## Jeanie Bourke - Re: 767 Congress St., BP#2014-00352 plan review comments

**From:** Michael Fraser <freemikenow@gmail.com>  
**To:** Tyler Brinkmann <tylerbrinkmann@gmail.com>, <jmb@portlandmaine.gov>  
**Date:** 5/30/2014 10:32 AM  
**Subject:** Re: 767 Congress St., BP#2014-00352 plan review comments  
**Attachments:** BRAMHALL PLAN.pdf; BRAMHALL STAIRS.pdf

1. Provide the bar fixture and equipment layout, and contact the Public Health Dept., Mike Russell, 756-8008 for confirmation of Food Code requirements, provide all revisions.
2. Clarify the existing bathroom layout, the new plan is not consistent with the previous plan if you are just replacing fixtures. It looks like the rooms are being reconfigured.

Drawing file: 4. Revised Plans / G4 proposed finished space.pdf

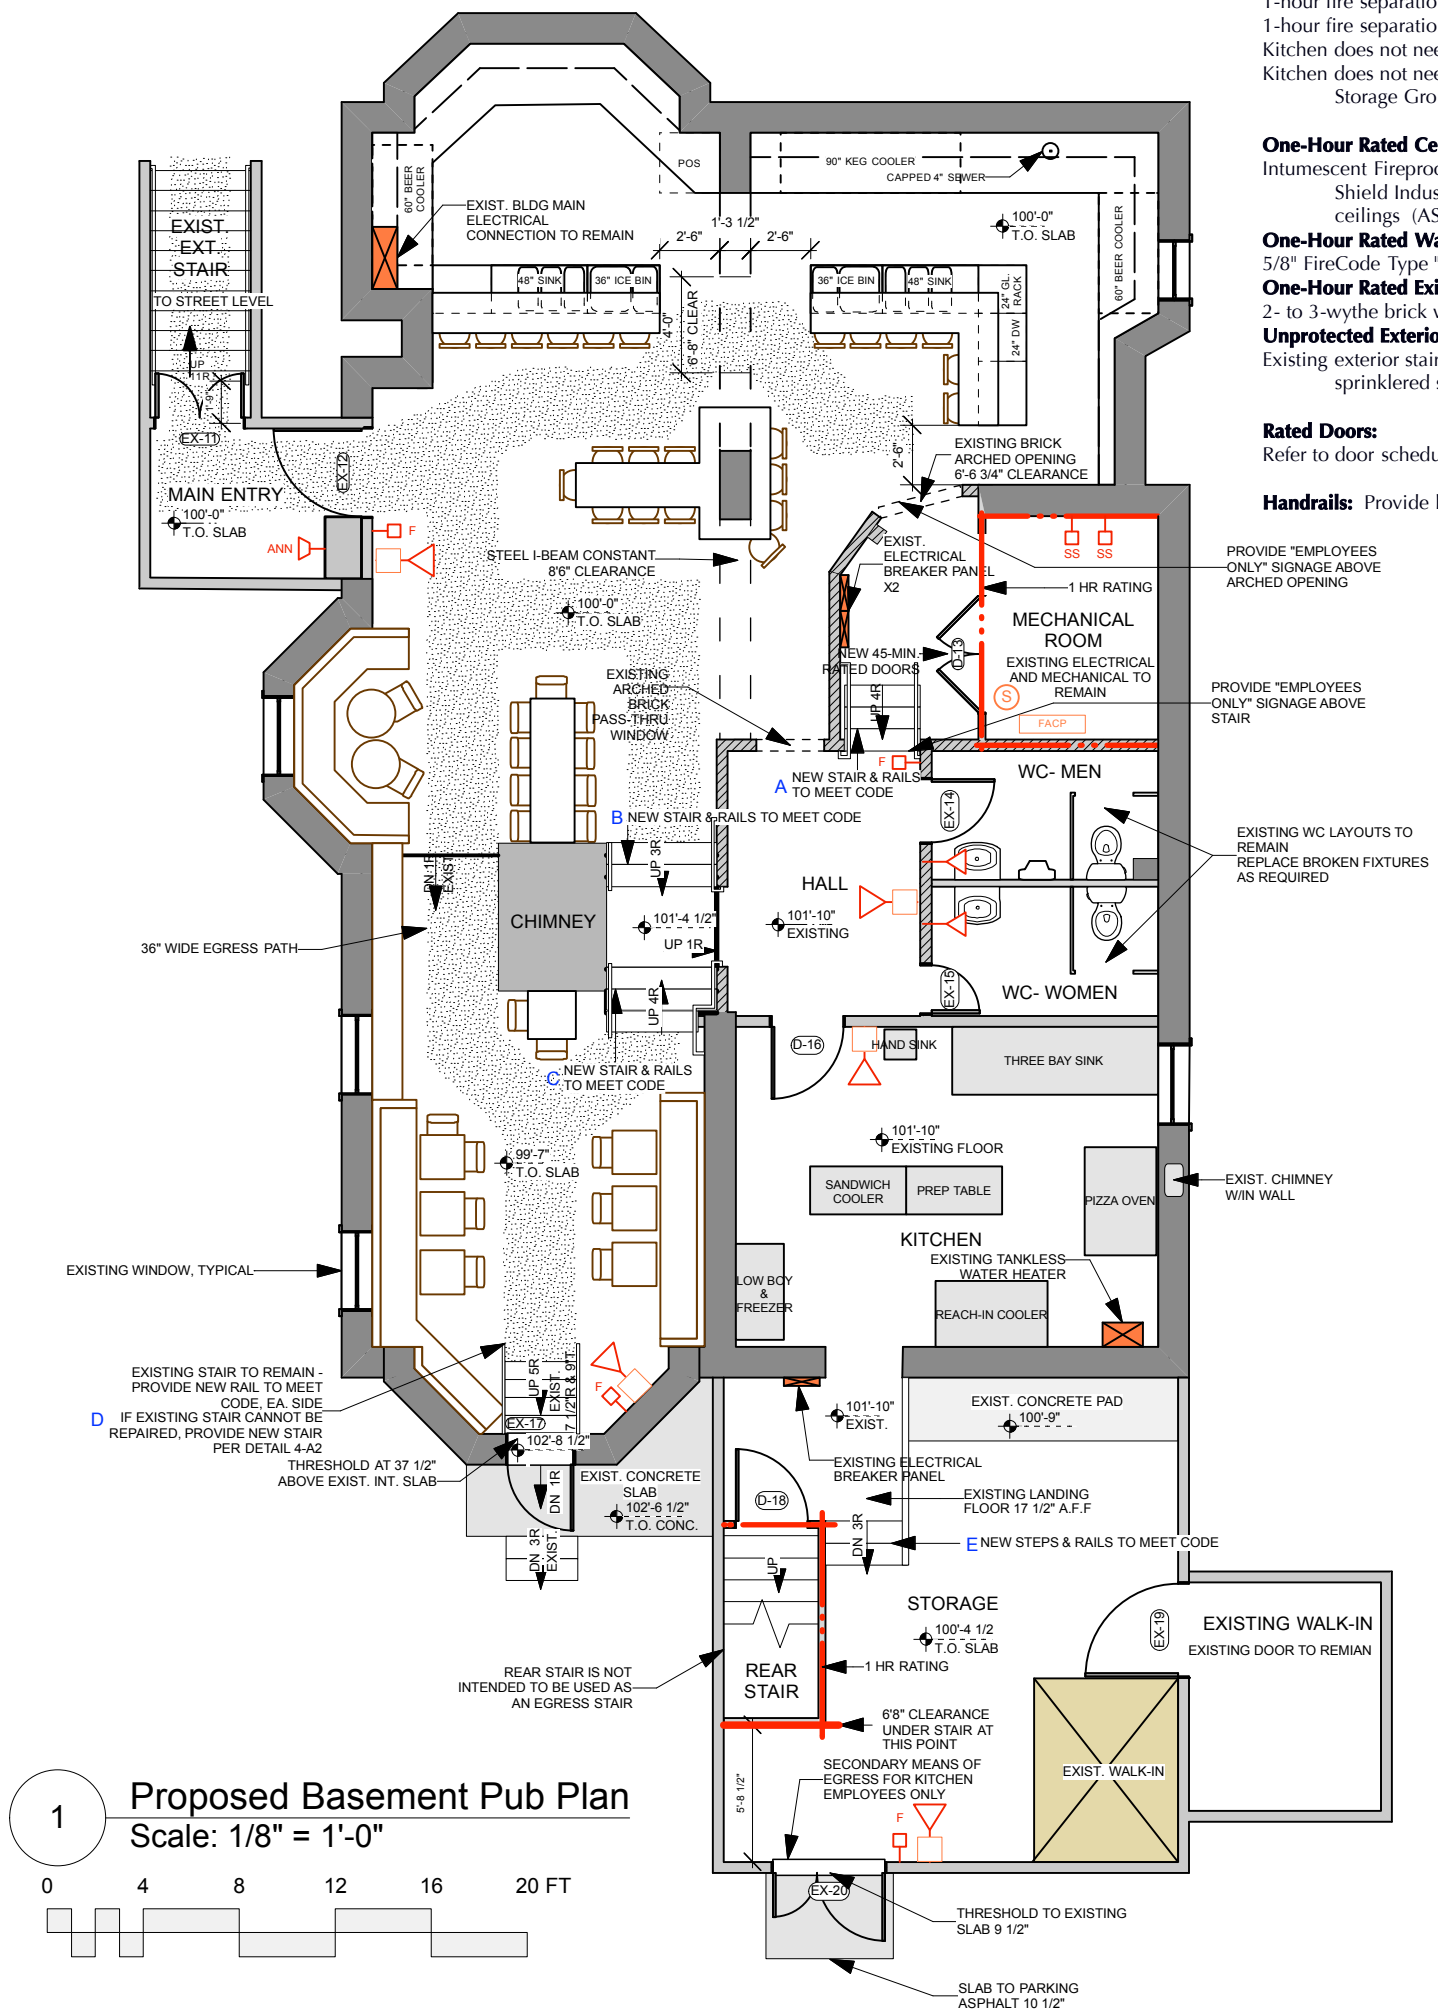
3. Clarify if the new concrete floor is being added where and how.
4. Provide a stair section showing the typical rise and tread profile and dimensions.

- 2) In our original plans, we had hoped to move them, but we are not now, so the plans now reflect what the current layout is, there will be no changes to the bathroom layout/fixtures.

- 3) We had hoped to do a radiant floor, we are not. The concrete floor will simply be "polished / sanded" and refinished. There will be no changes in the height or additional concrete added.
